Sent: 20 March 2019 12:24
To: Planning Scanning
Subject: FW: Planning Consultation on: LU/59/19/PL

Engineers Comments Regarding Surface Water Drainage

Site Address: Land at Watersmead Business Park Worthing Road
Littlehampton BN17 6LS

Description of Works: Installation of 5 No. 'vehicle-to-ground' lifts, HVAC plant units, a canopy cover over the associated service yard area for a temporary period of five years, installation of 3 No. level access doors, minor alterations to internal access road including widening works, creation of a new spur, provision of a pedestrian footbridge & associated lighting & drainage infrastructure provision.

EE CANOPY SECTION
1 : 200

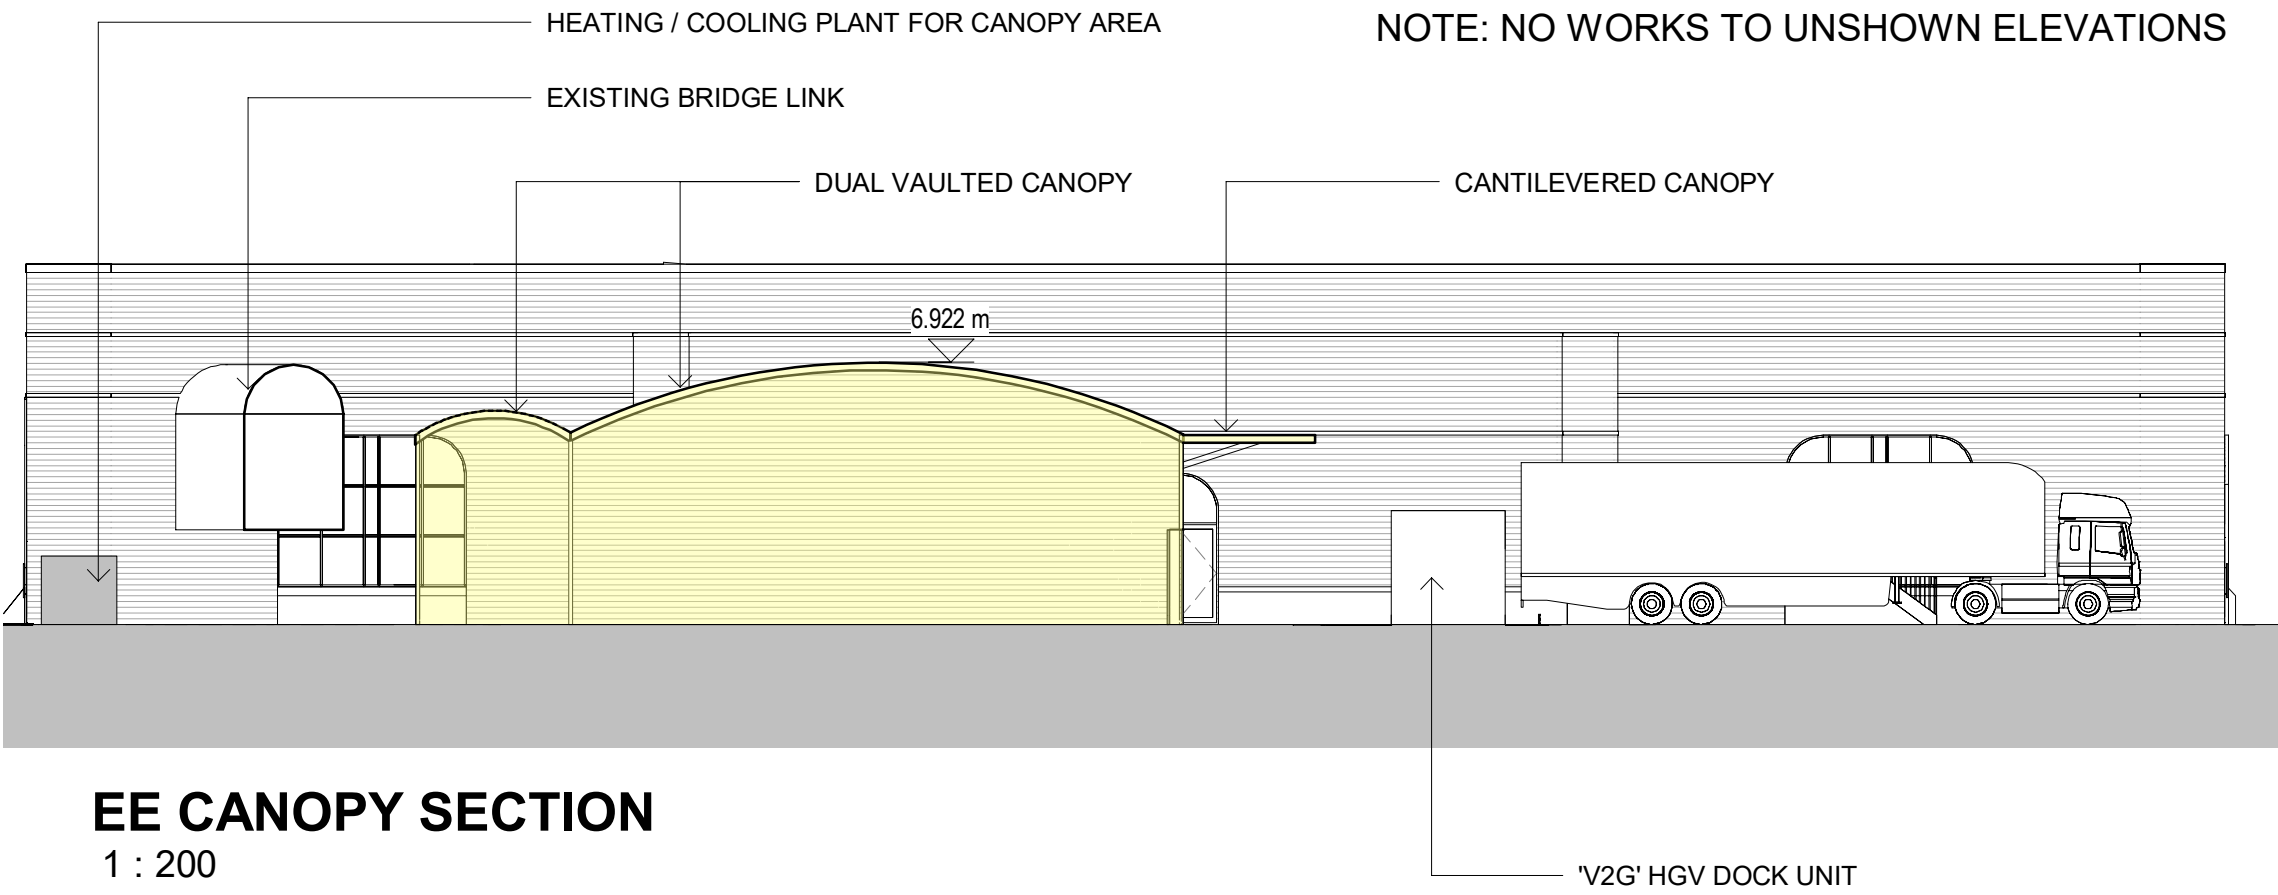
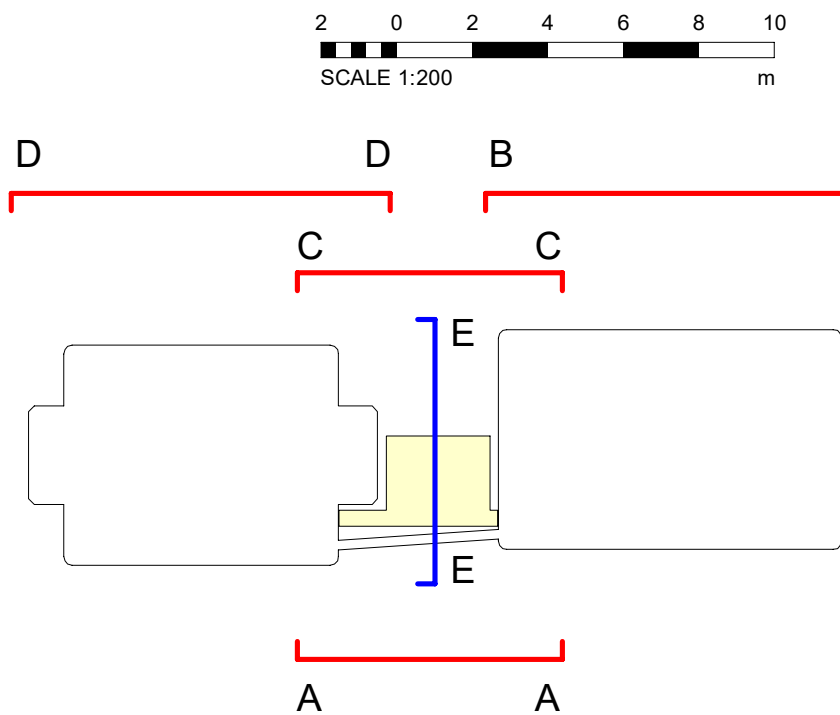
A significant area of canopy is proposed. Details regarding the existing surface water drainage should be provided in order to demonstrate that the proposals will not damage the existing drainage or prevent maintenance being completed. It should also be demonstrated that sufficient surface water drainage can be provided. If these details cannot be provided before determination please apply PCENG2.
